FG/136/25/L

Yew Tree Cottage 11 Ferring Street Ferring BN12 5HL

Listed building consent to form a new vehicular access following the removal of gate and demolition of wall. (This application may affect the character and appearance of the Ferring Conservation Area).

PROPOSED NEW ENTRANCE & DRIVE TO YEW TREE COTTAGE, FERRING ST. BN12 5HL
 DRWG. NO. 11/01 JULY 2025

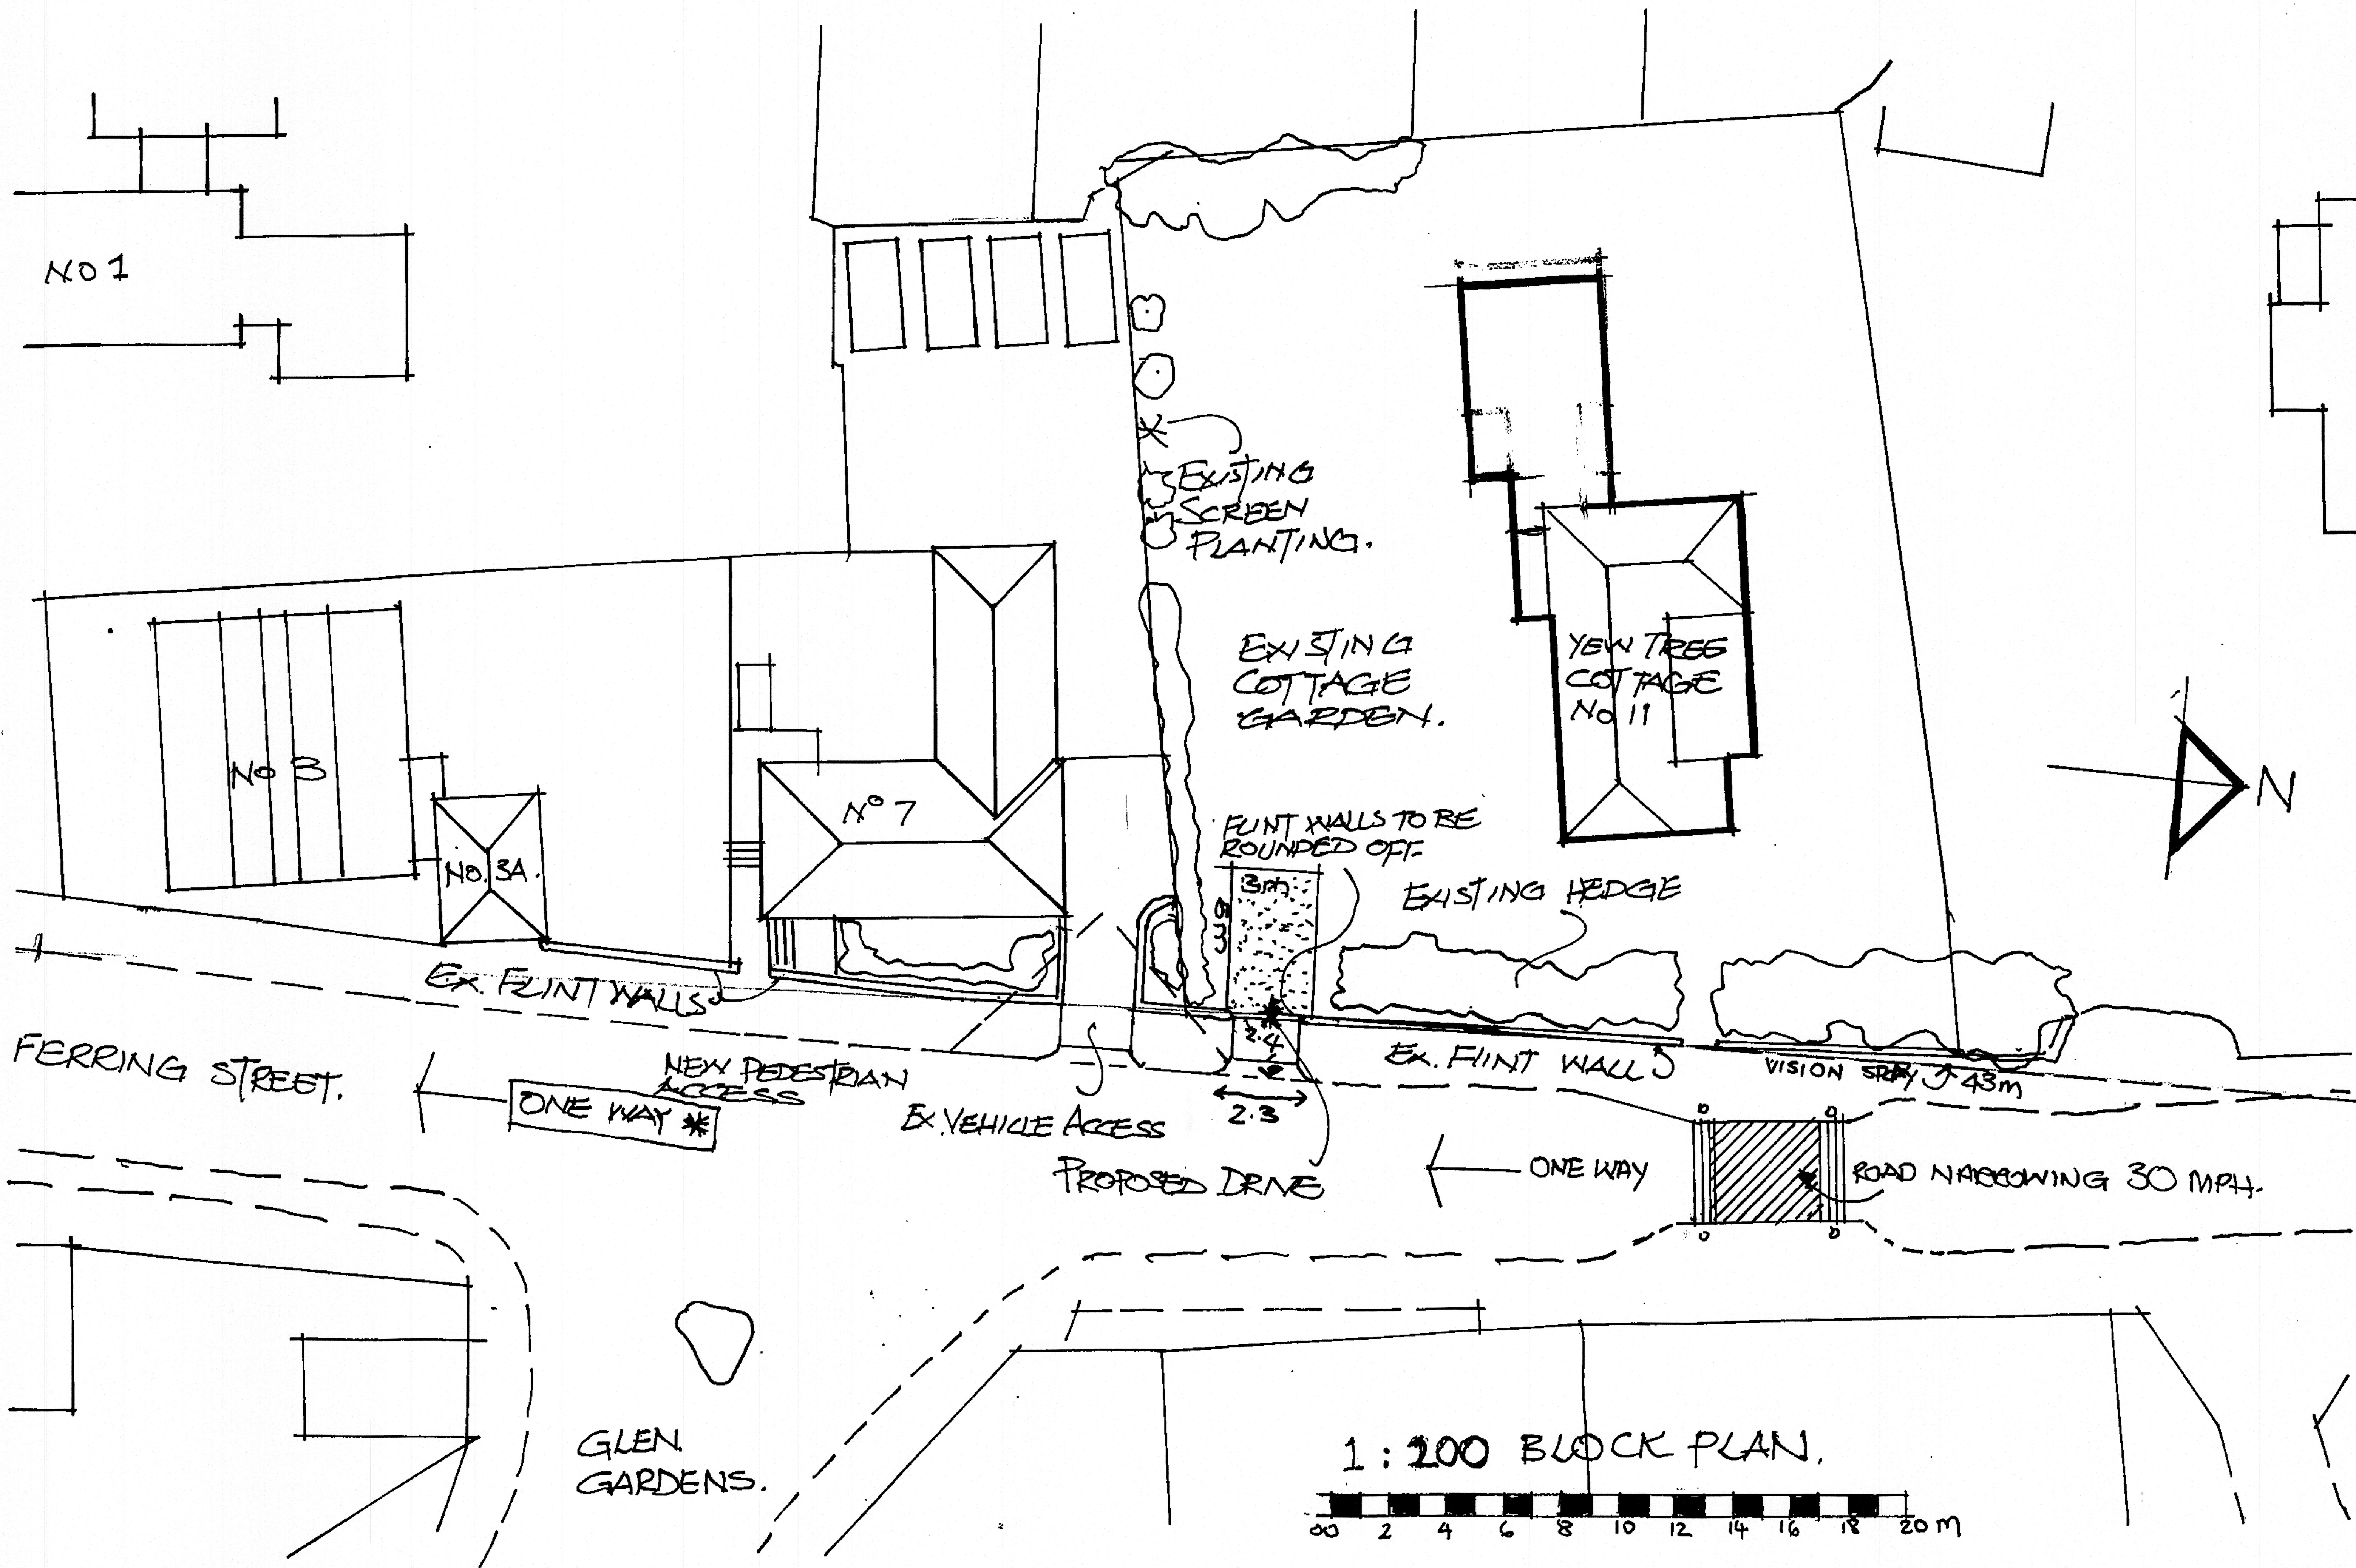
If the concept of removing the section of walling is ok in this particular instance, then the implementation and design is more important. As currently presented, the wall would simply terminate at the opening, leaving a visually abrupt gap in the boundary. The design of the opening therefore warrants more careful consideration. A design-led approach (which is currently lacking) would help to ensure that the opening reads as an intentional feature rather than an afterthought, while also compensating for the loss of original walling and enabling the reuse of existing flint within the property.

One practical and sensitive mitigation measure could be to introduce new sections of flint walling on either side of the access, extending into the garden frontage. This would preserve the visual continuity of the boundary. To maintain quality and authenticity, a sample panel of the new flint walling should be agreed with the Council as part of a planning condition.

In addition, the landscaping and planting should be protected, with any shrubs or greenery removed replaced as part of a well-designed scheme. This would help soften the changes and maintain the street's green, leafy character.
